Development Control
Ribble Valley Borough Council

Re: Planning Application 20/0185

Address: 1 Brookfield Mellor BB2 7JN

Description: Proposed two storey extension to rear and new first floor window in the gable. Demolition of outbuilding.

0 PROPOSED GROUND FLOOR

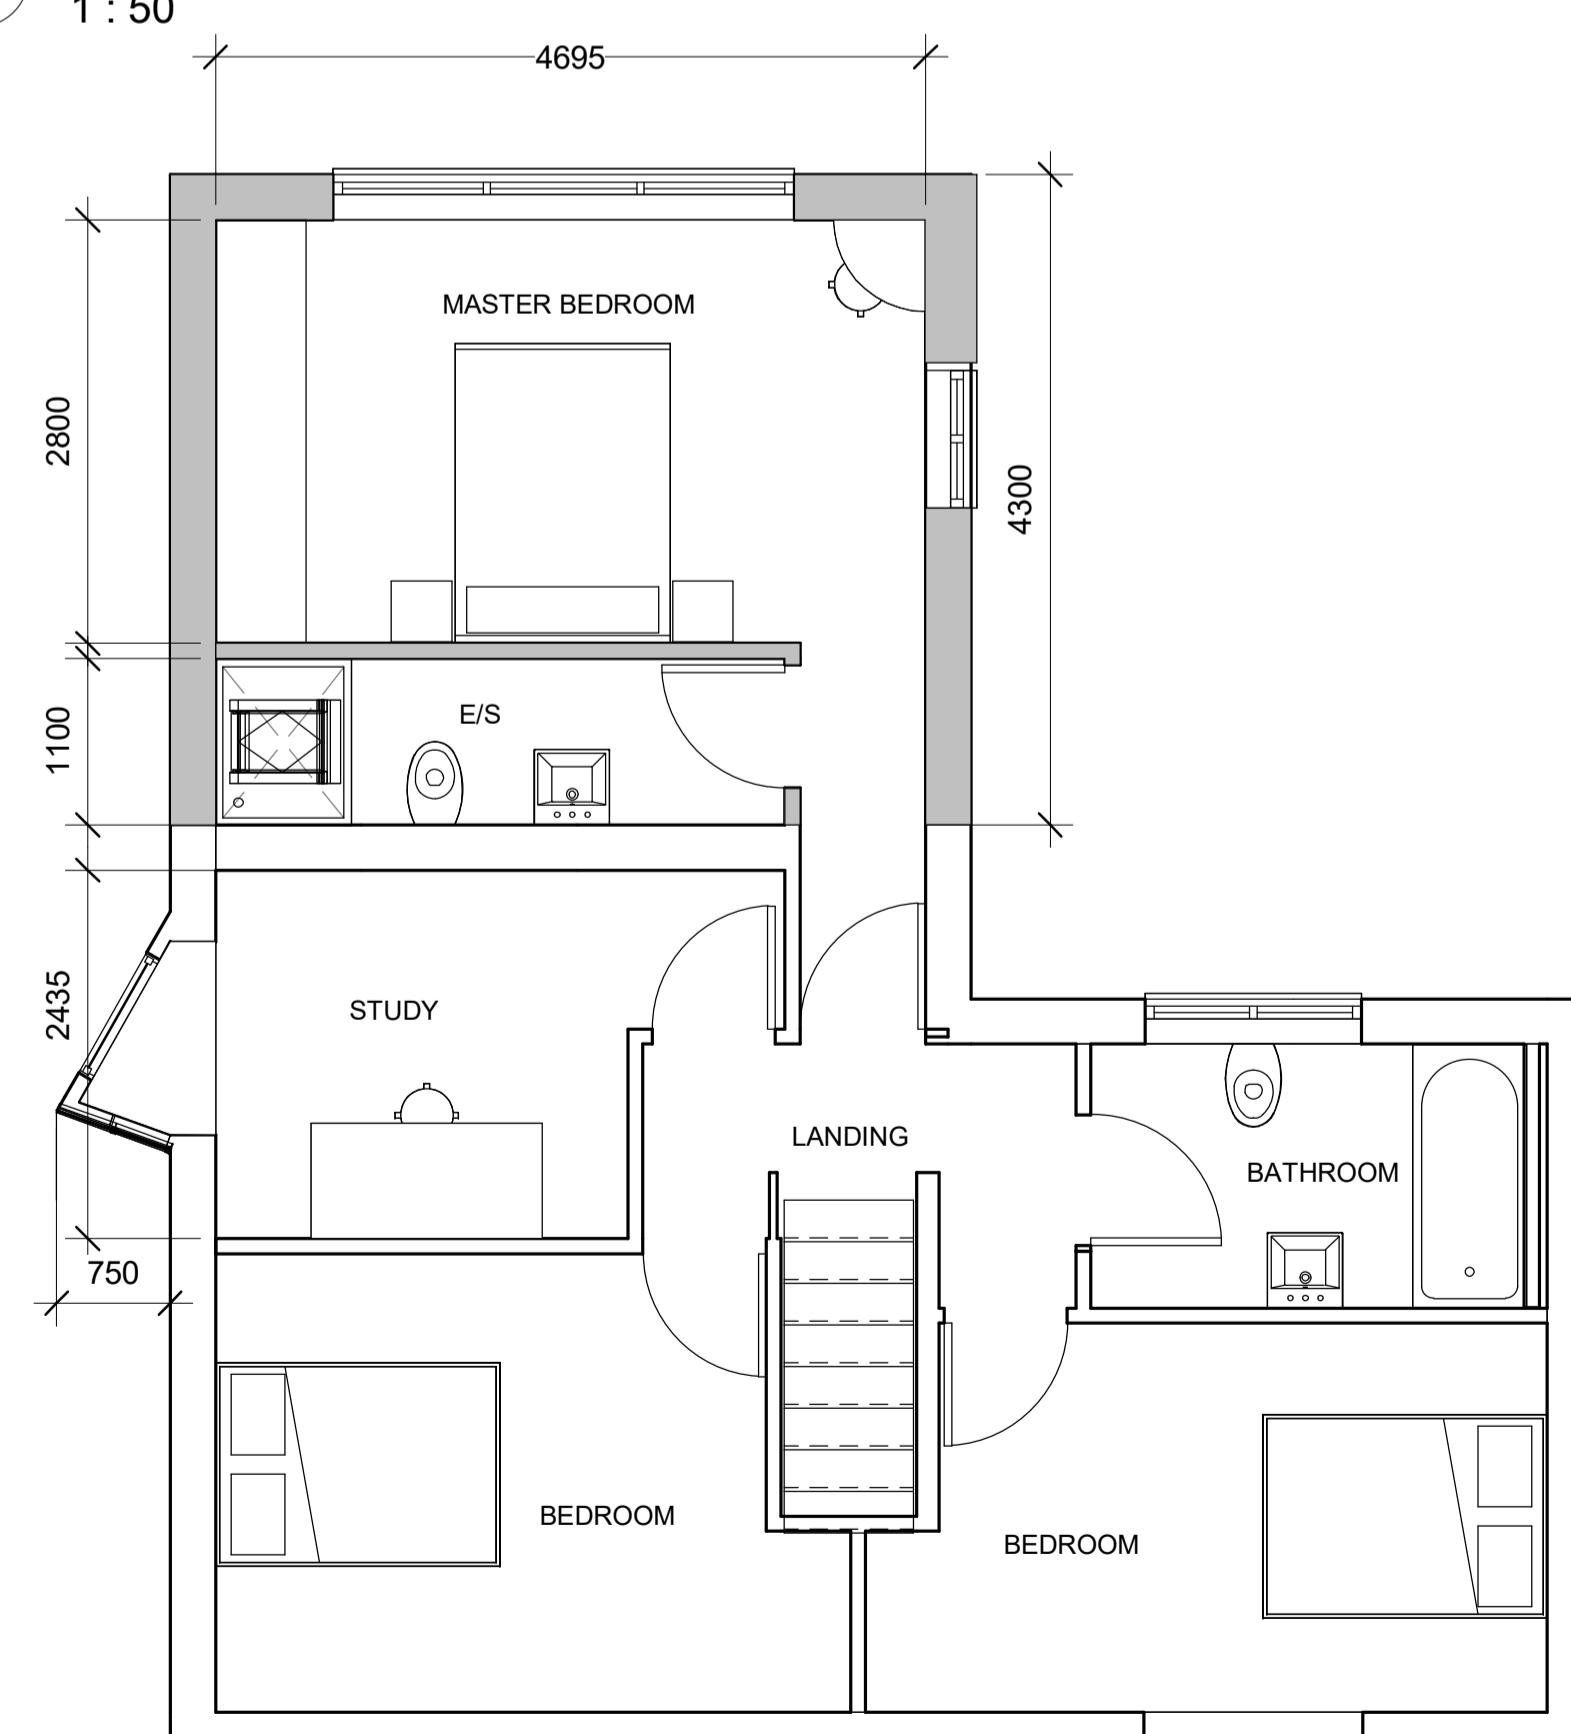
With respect to this application whilst we would not wish to raise an objection the principle of the development. There is however a concern regarding the lack of detail regarding the boundary treatment to the rear and the surfacing of the driveway. Additionally, photographs supplied by the applicant would indicate that there is a drive and a dropped crossing to the front of the property.

- What is the boundary treatment to the rear?
- If any gates are to be used they shall be restricted from opening over the adopted highway,
- The driveway shall be surfaced with a bound material to prevent debris being carried on to the highway,
- Any wall fence or similar treatment to the rear shall be kept to a maximum height of 1m for a distance of 10m from the boundary line with property No 3.
- If the driveway to the front of the property is to be removed then any lowered footway shall be reinstated.
